Subject: Planning Application AL/123/17 - Mildmay, Hook Lane, Aldingbourne

I am writing to object to the above application as the proposed structure is out of keeping with the surrounding properties on the lane inasmuch as:-

DRAWING TITLE:
PROPOSED FRONT ELEVATION

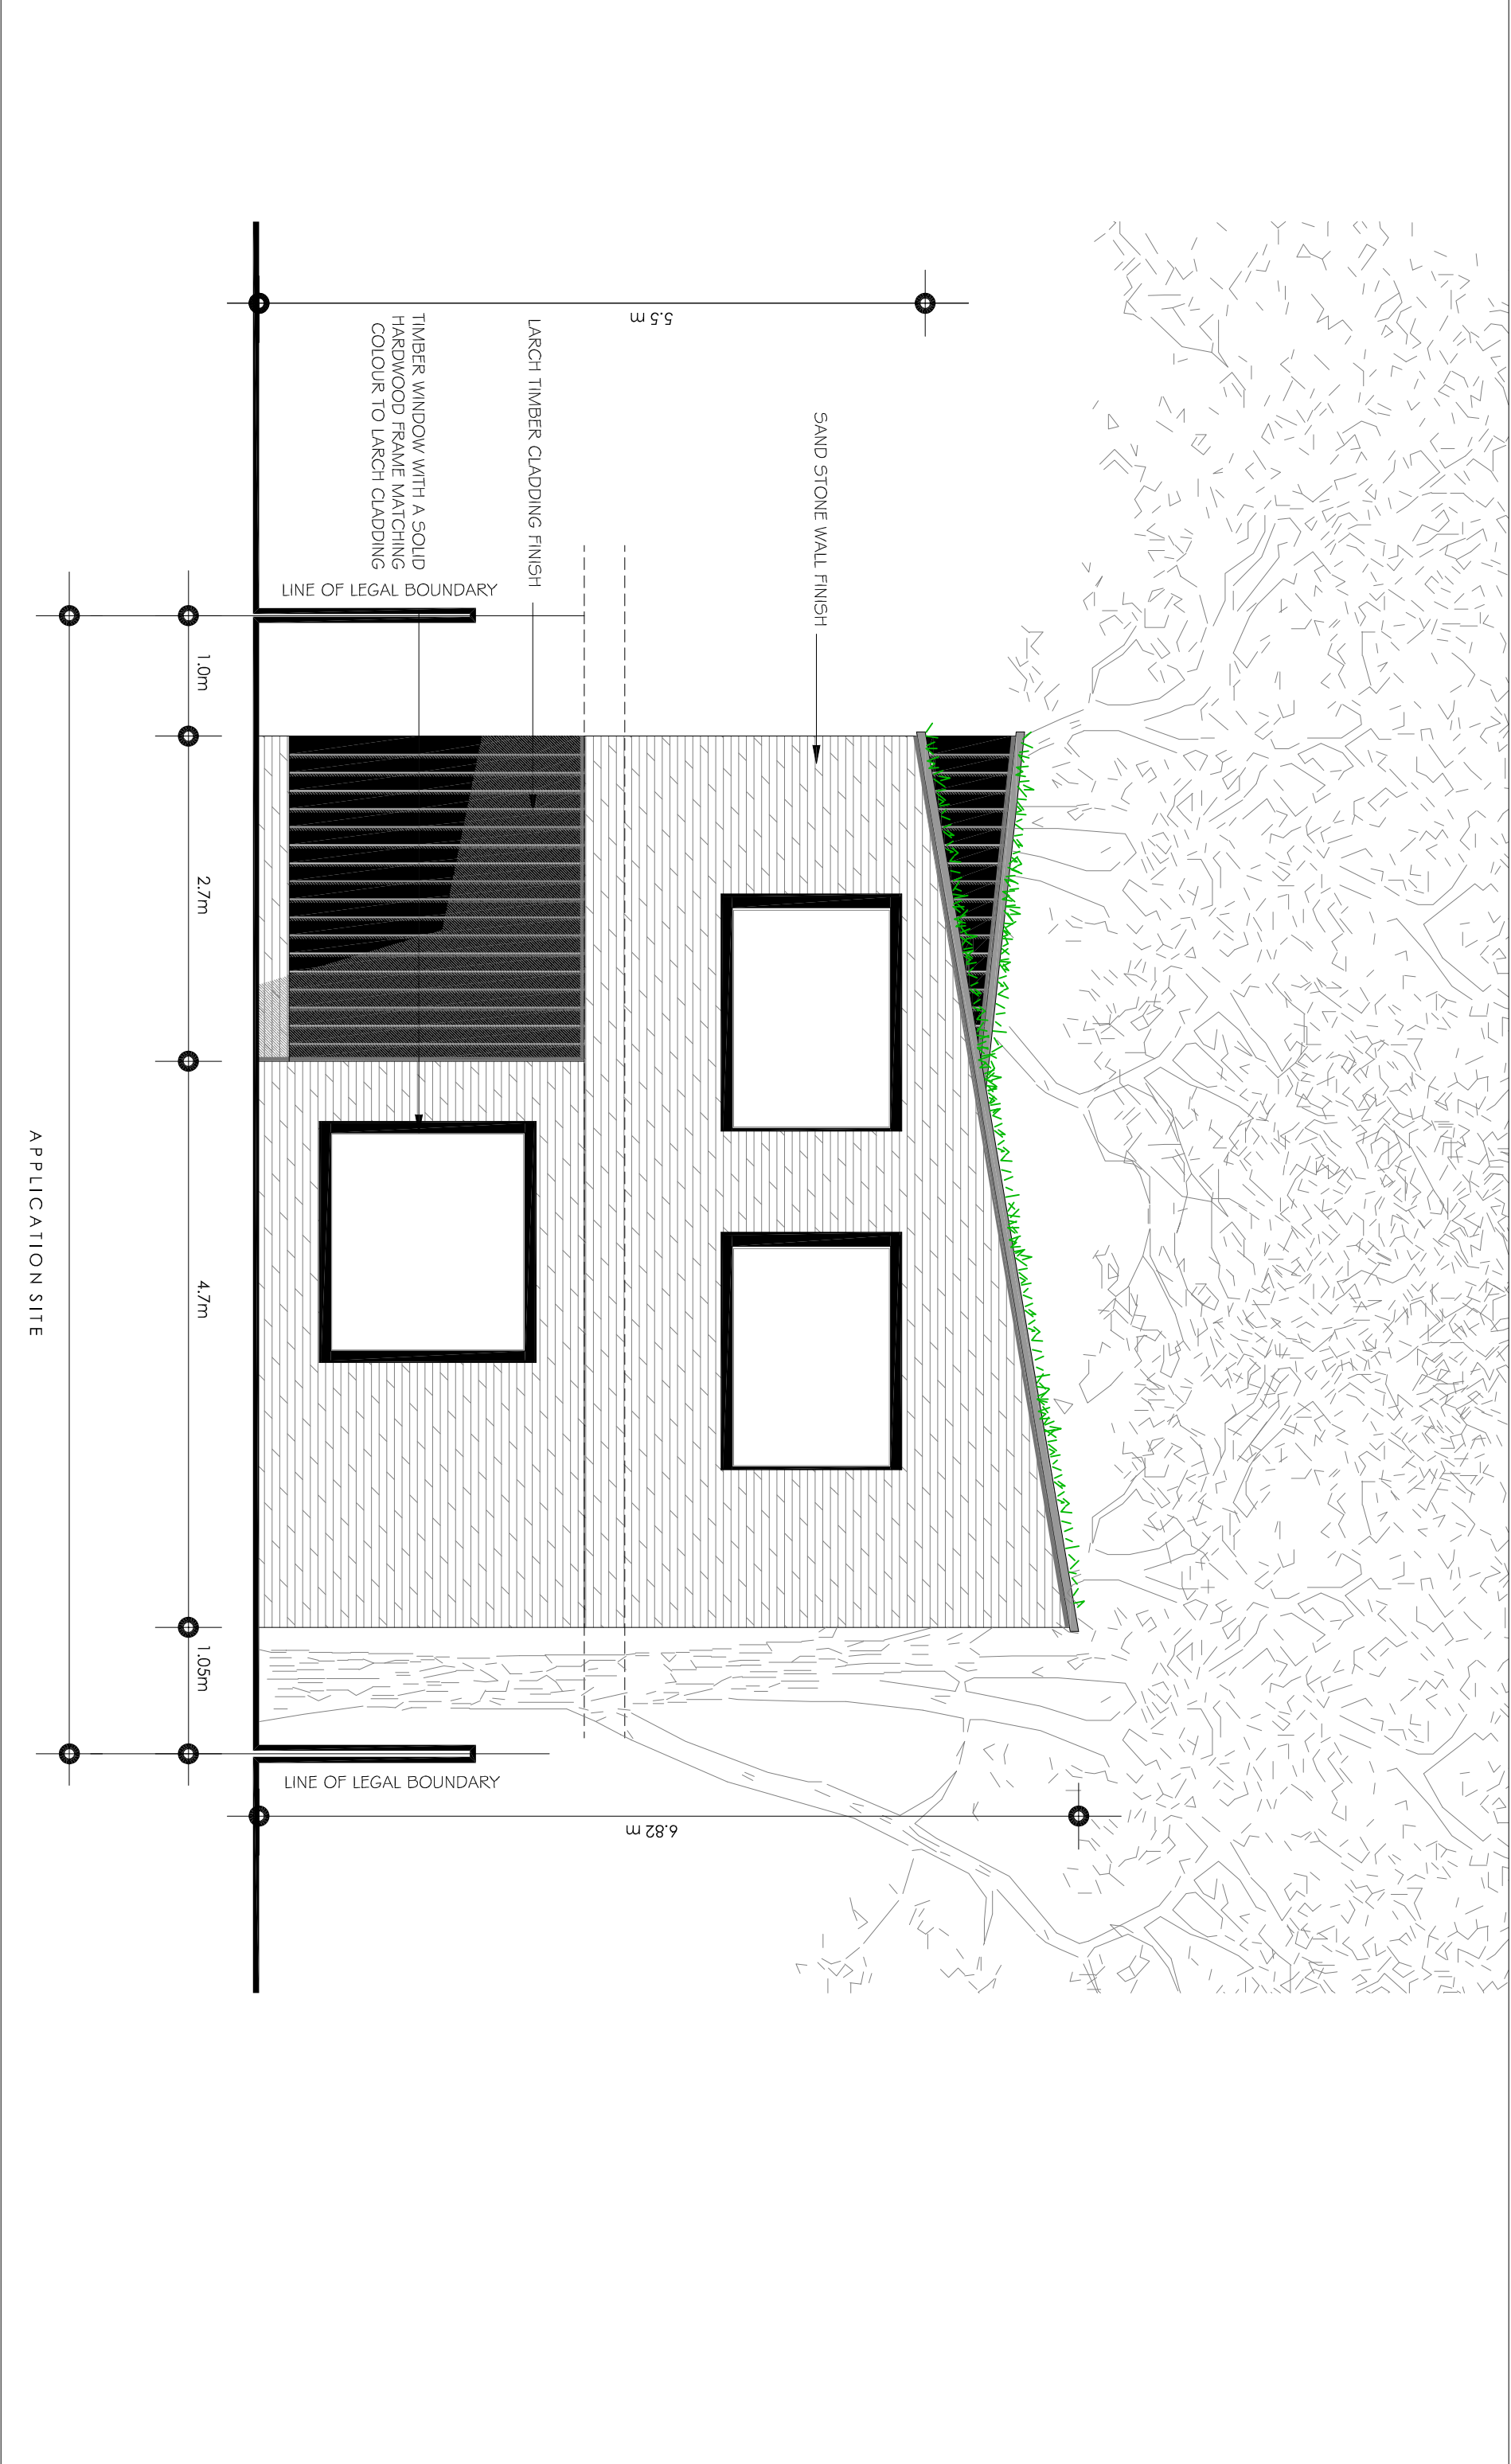
- 1) It is proposed to have a flat roof whereas all existing properties have pitched roofs, and, recently an extension was turned down on this basis
- 2) The proposed 'overhanging' upper storey will dominate the properties either side and will no doubt greatly reduce light levels.
